Engineers Comments Regarding Surface Water Drainage

Application Reference:	FP/10/26/DOC	Reviewer Reference:	ADC/EXT5/AF
Planning Officer:	Daniel Vick	Date of Review:	15/06/2026
Site Name:	Land off Stanhorn Grove Felpham PO22 8FA		
Application Description:	Approval of details reserved by condition under FP/32/25/S73 relating to conditions 6 & 7 - drainage.		
Assessment Number:	2

Application Reference: FP/10/26/DOC Site Name: Land off Stanhorn Grove Felpham PO22 8FA	Initial Issue Date: 16/02/2026 Issue Date: 15/06/2026 Reviewer Reference: ADC/EXT5/AF
--	---

DRAWING TITLE
Drainage Layout

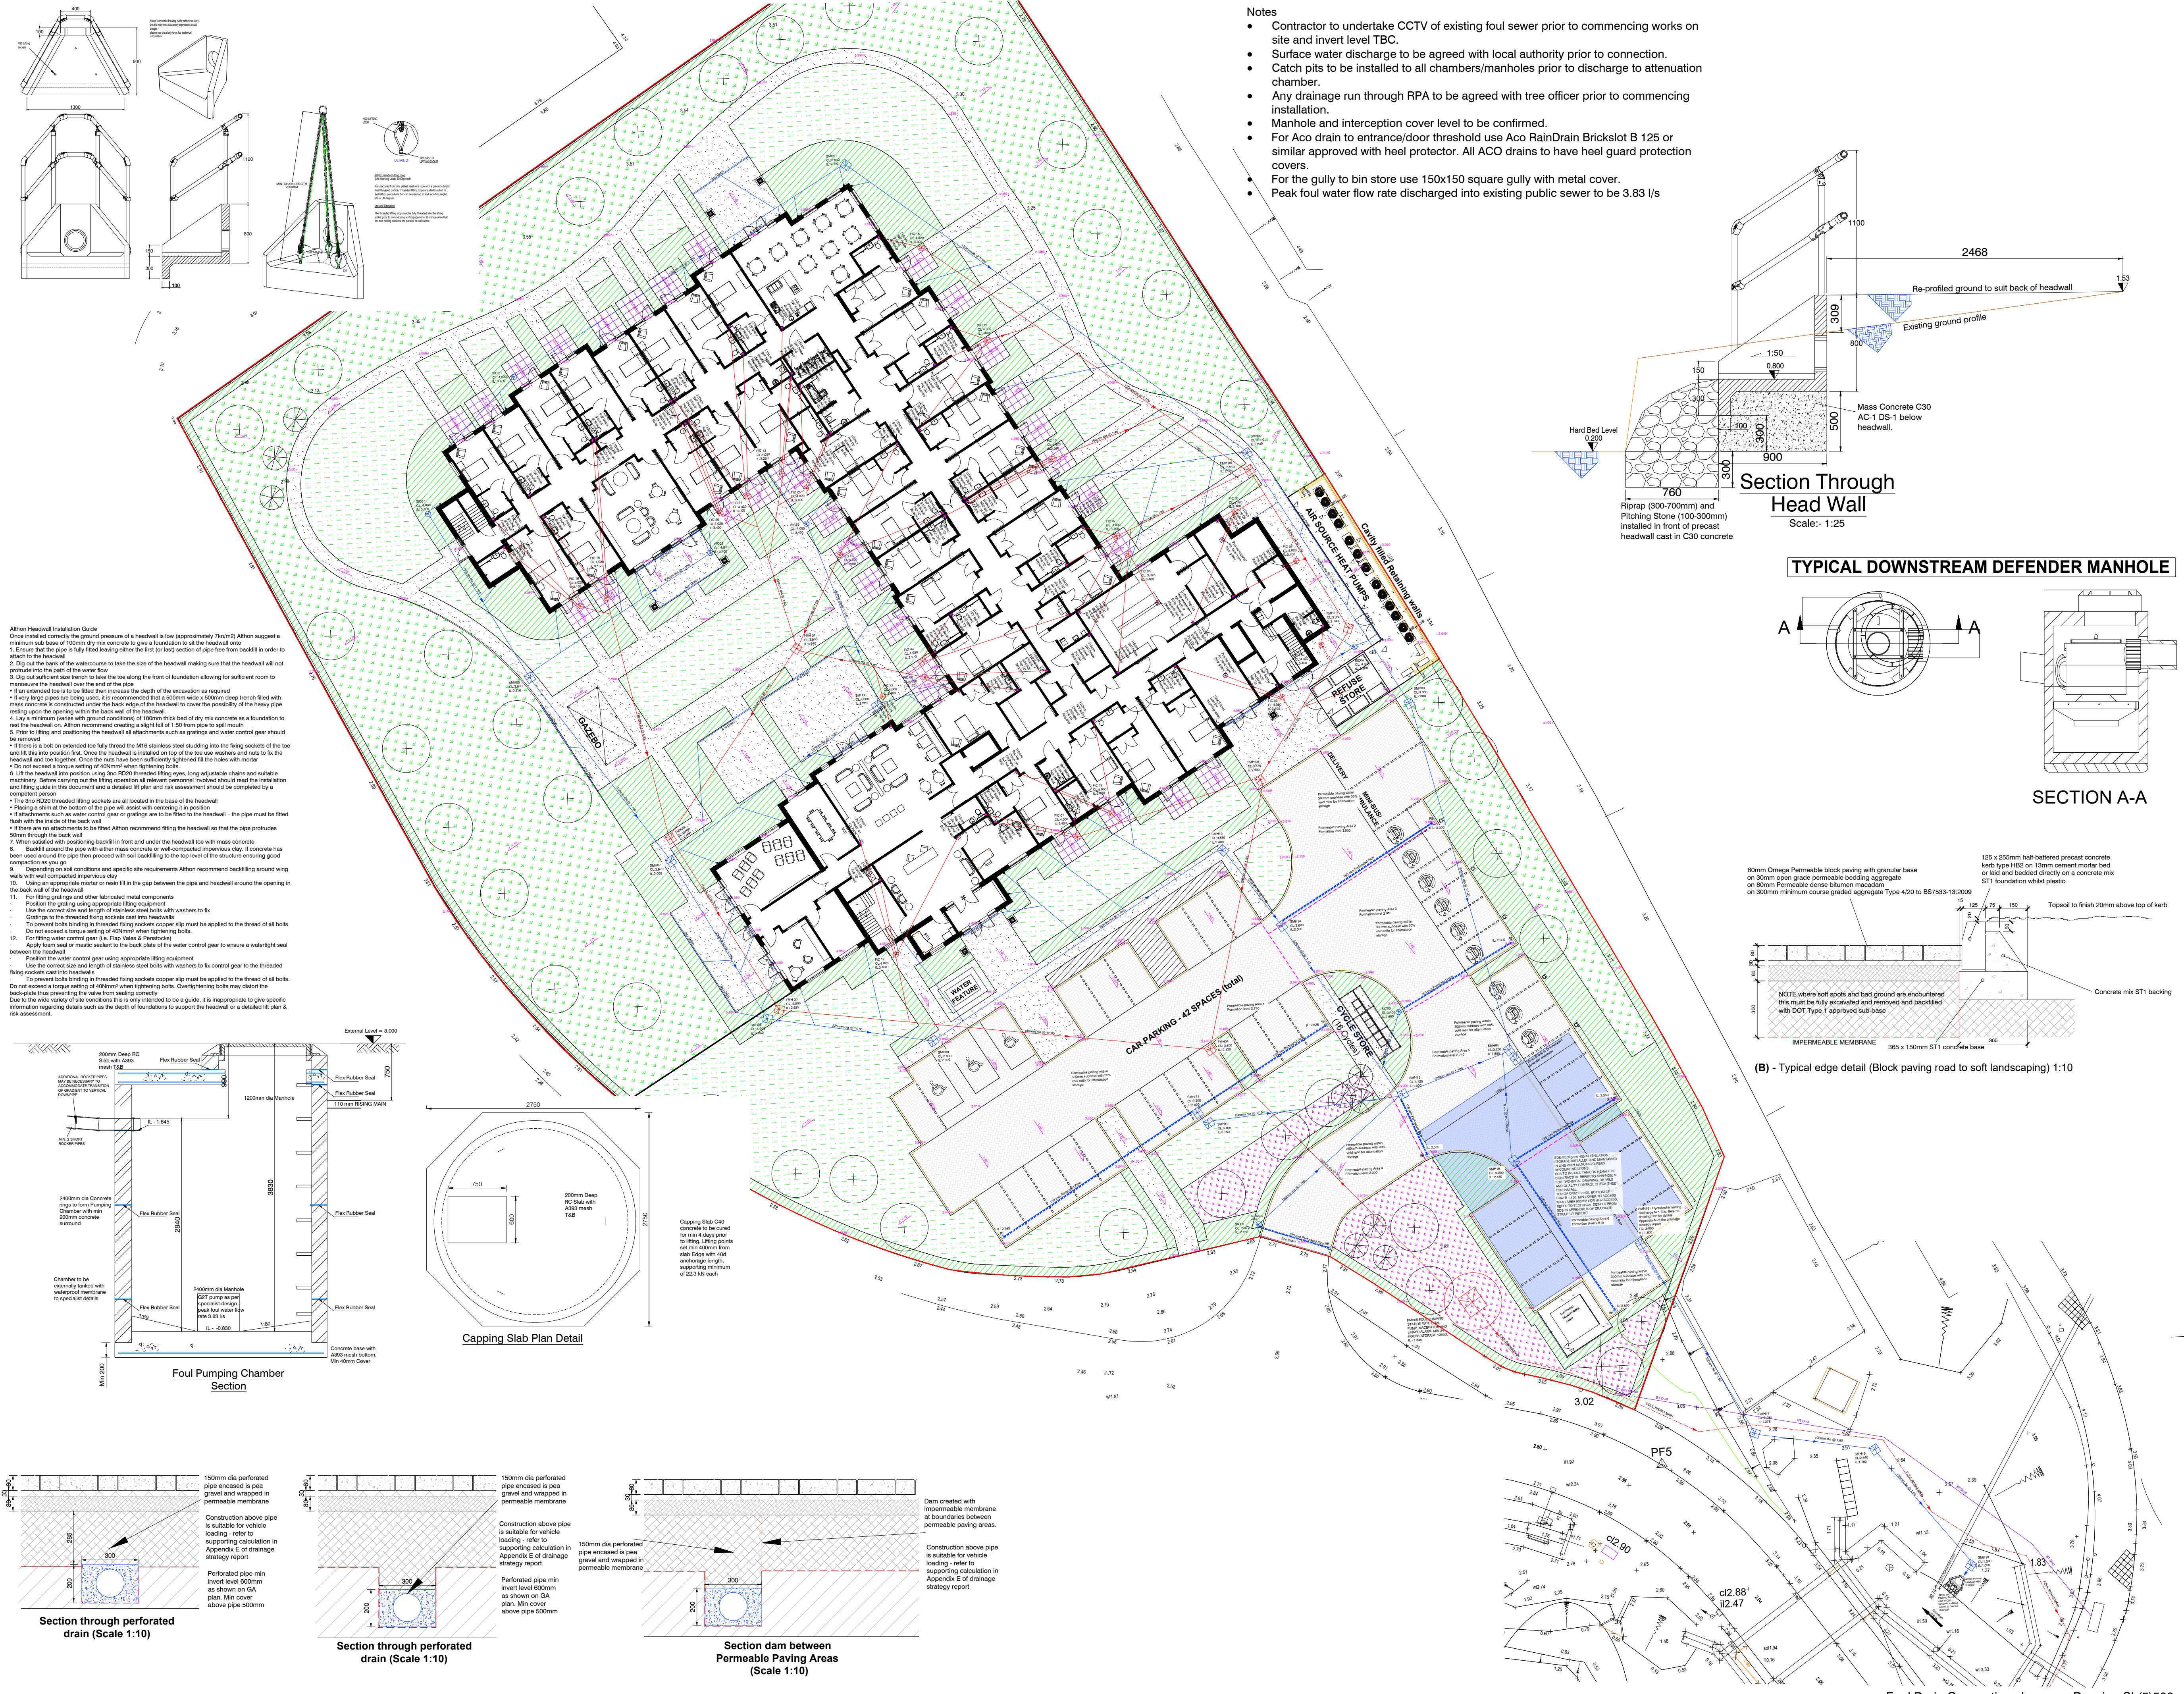
12.				Additional comment: There are a number of permeable paving compartments which are not physically segregated. They are not defined in plan and it is difficult to audit the areas. The overflow level in the plans appears to be 2.78m AOD. The modelled compartments all have higher exceedance level and fill to higher levels during the design storm, some clarification is required to confirm that the permeable paving would fill to the modelled levels without overtopping at the low point of the combined construction.

13.				Additional comment: There are trees shown within the plan

area of the crate storage installation. The coordinated design needs to be confirmed to ensure the trees will not damage the installation.	
Condition Number: 7

Technical cross-section drawing of a head wall structure. Key dimensions and components include:

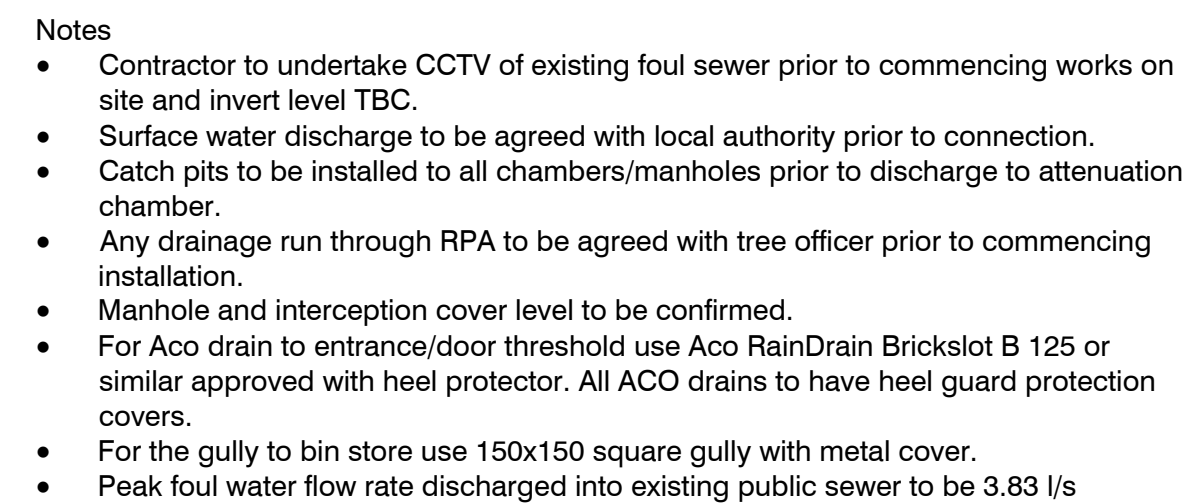
infiltration across the site. An additional test in the location of the proposed soakaways should be provided during winter or spring months.				
3.	Construction details should be provided for all drainage elements including the permeable surface paving and the soakaway.	See updated drawings I Appendix F	A construction detail should be provided for the flow control chamber.	A detail is provided but it does not appear to comply with the recommendations of the flow control device manufacturer. This should be checked and updated. There is also a concern that the crate installation detail does not contain sufficient detail to guarantee watertight construction. This is essential as it is below the high groundwater level. The crate installation must be fully watertight with welded joints formed in an impermeable membrane protected from puncture and using watertight pipe connections. This is not clear from the detail provided. The perforated pipes within the permeable pavement appear to be shallow and unprotected and therefore susceptible to collapse under vehicle loading, the detail should be clarified.
